Recommendation Report for Planning Permission for Works or Extension to a Dwelling

REF NO: LU/90/26/HH

LOCATION: 2 Old Warehouse Mews
Western Road
Littlehampton
BN17 5GE

PROPOSAL: Replace existing timber windows with PVC windows and existing timber doors, Front and Back with GRP doors of similar design. Overline existing timber fascia boards with Hockey stick profile PVC fascia boards. This application is in the Littlehampton Sea Front Conservation Area.

EXISTING TIMBER WINDOWS

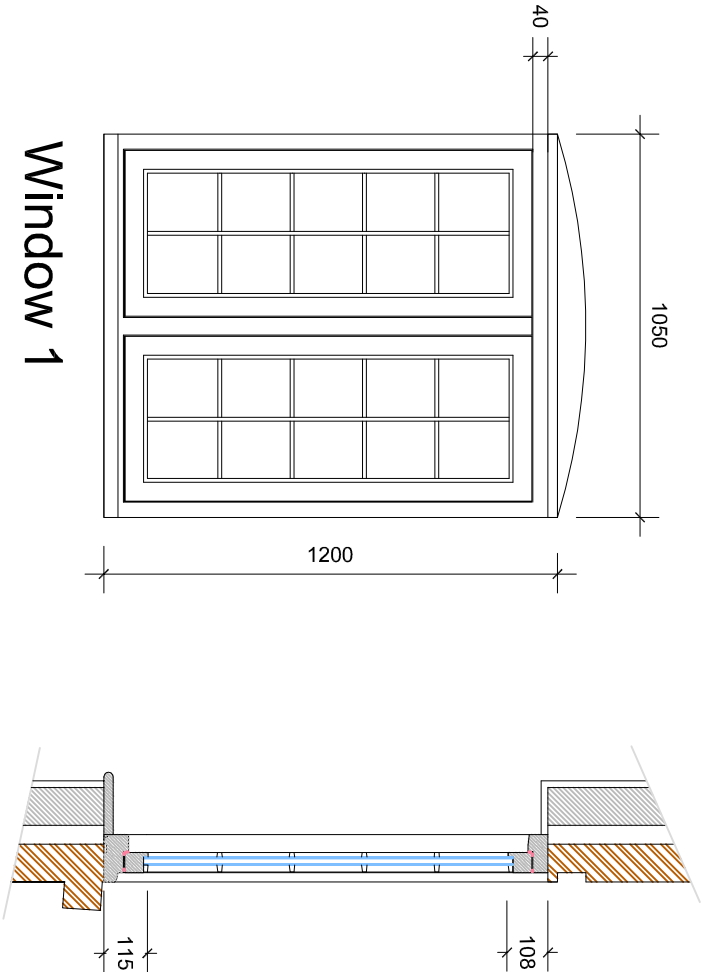
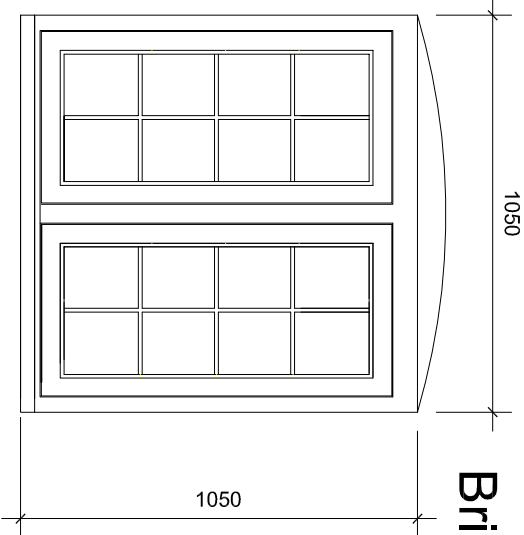
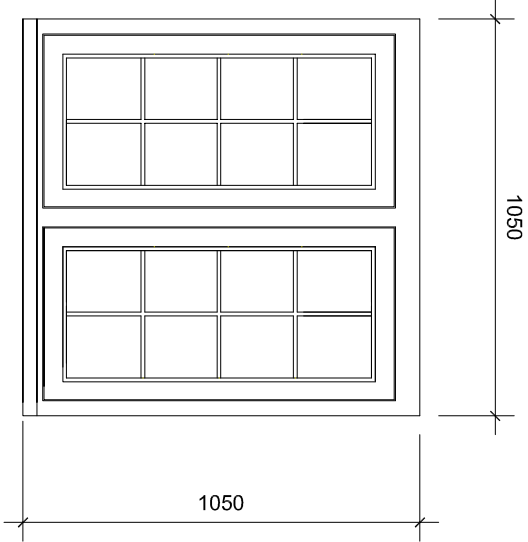
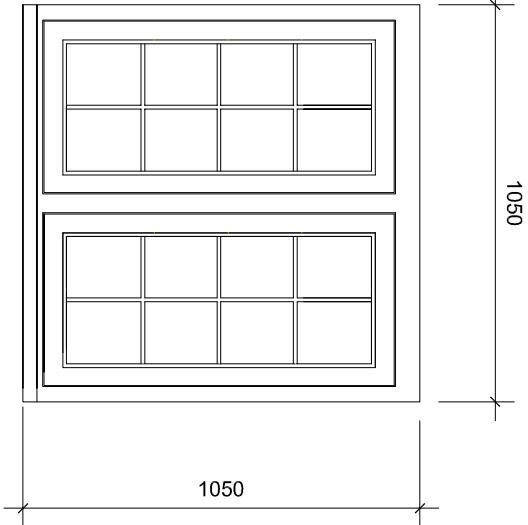
The existing windows are already of a relatively bulky appearance and would be replicated in proportions and detailing. The colour of the front door would be altered from light green to light blue, however, its overall appearance would remain broadly consistent with the existing.

PROPOSED PVC WINDOWS

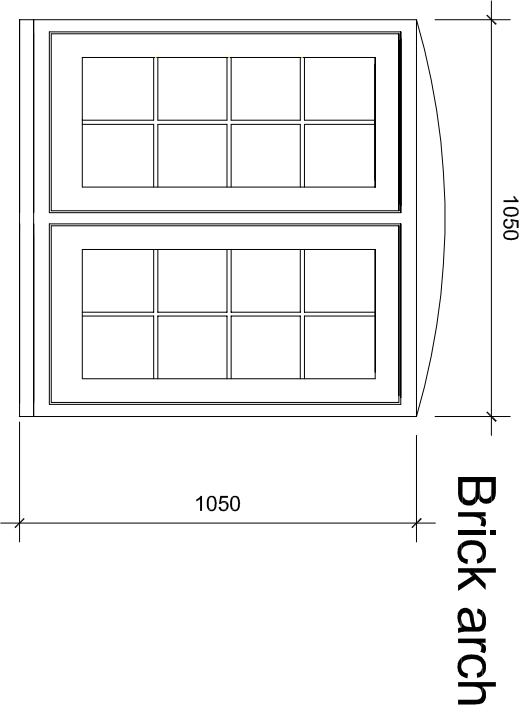
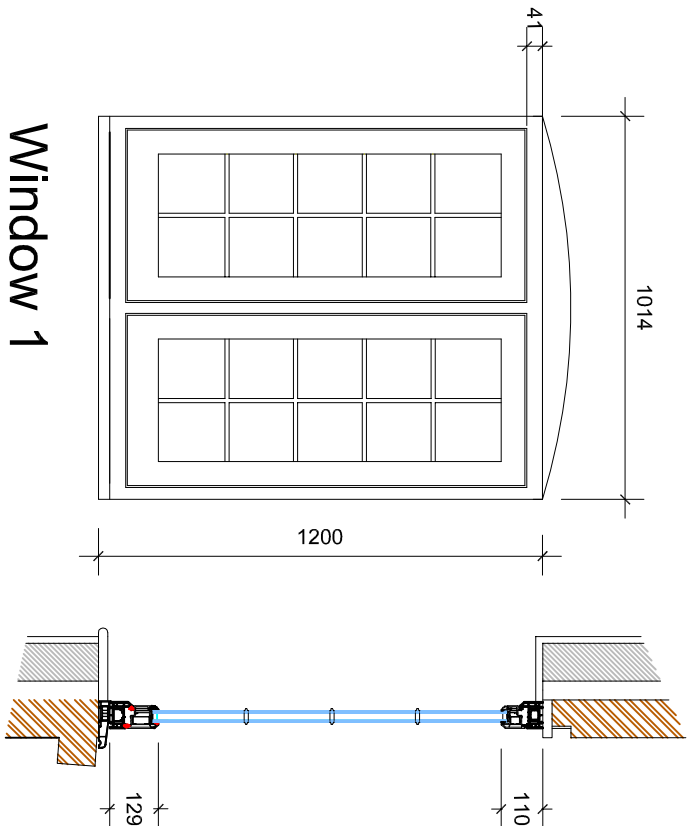
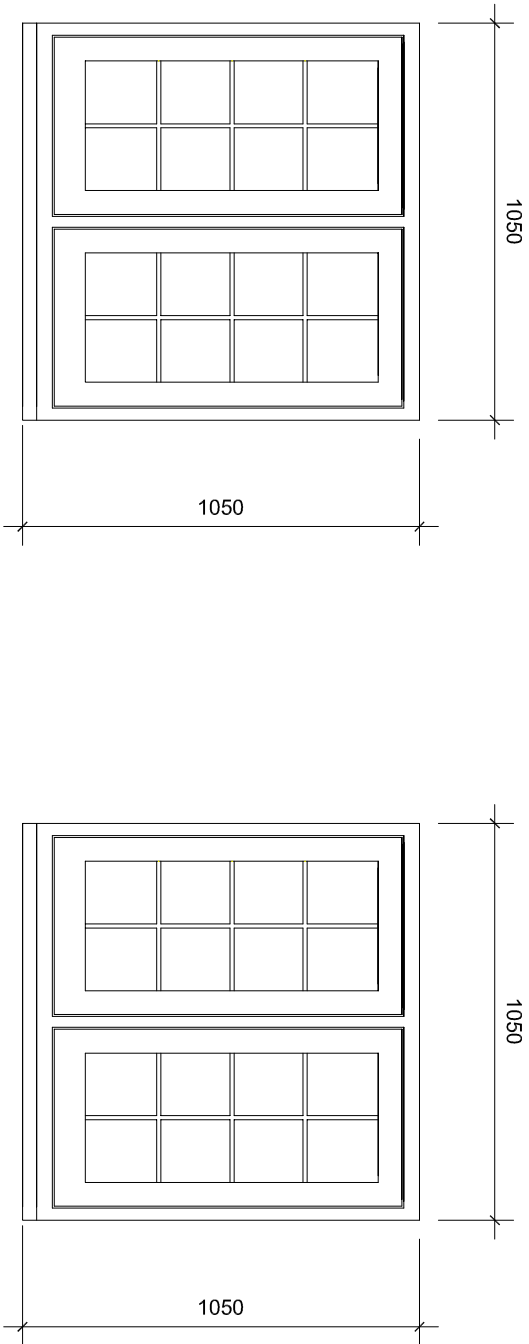
During the course of the application, the agent confirmed that the existing timber frames have a depth of approximately 60mm. The proposed uPVC replacements would have a comparable frame depth of approximately 62mm with sash depth of 63mm and would incorporate integral glazing bars to match the existing detailing.
